DRB CASE NO/PROJECT NO: 1005270

Sketch Plat

Re: Lot 9,10,23 & 24N.A.A. Tract A, Unit B/sketch

A3 SITE PLAN

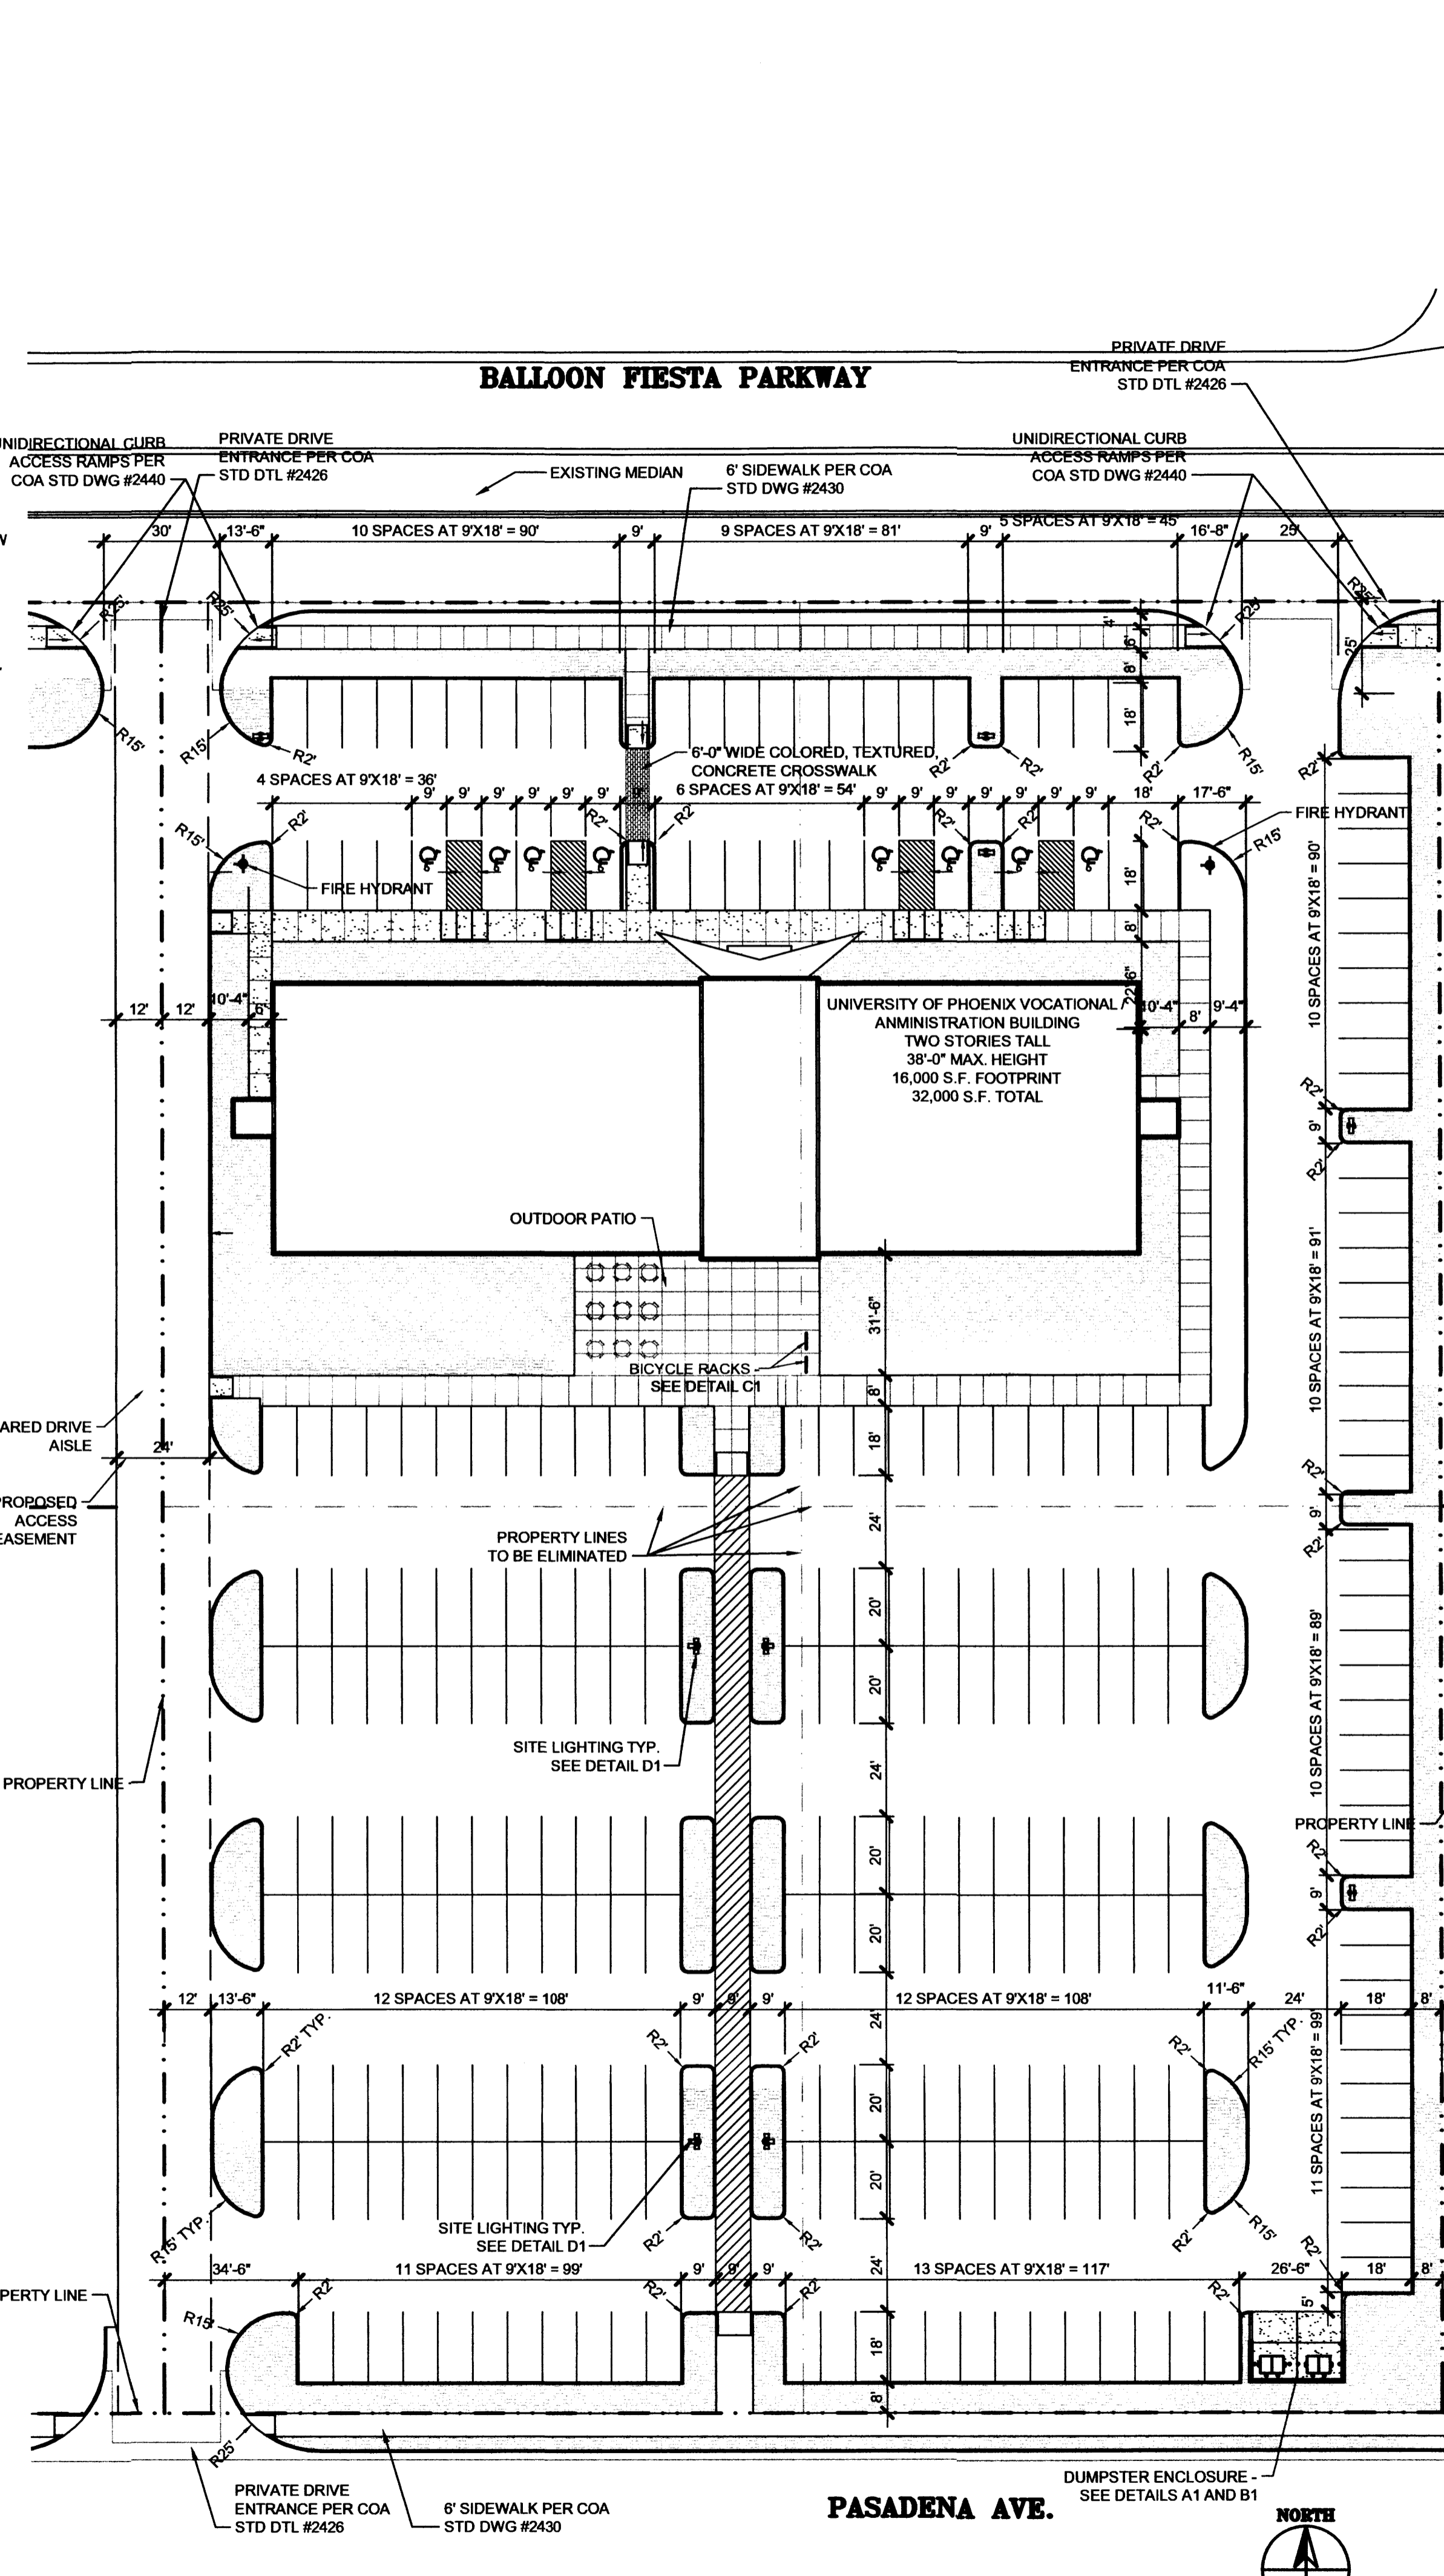
1. An infrastructure list will be required for this proposed plat. The infrastructure list will require construction of a 10" waterline and a 10" sanitary sewer line in Pasadena Road to cover the frontage of this parcel.
2. It will be necessary to get the City's Fire Marshal's approval for placement of fire hydrants on this parcel to adequately protect the proposed building.

A Site Plan for Building Permit is required because of the Community Facility that is being proposed.
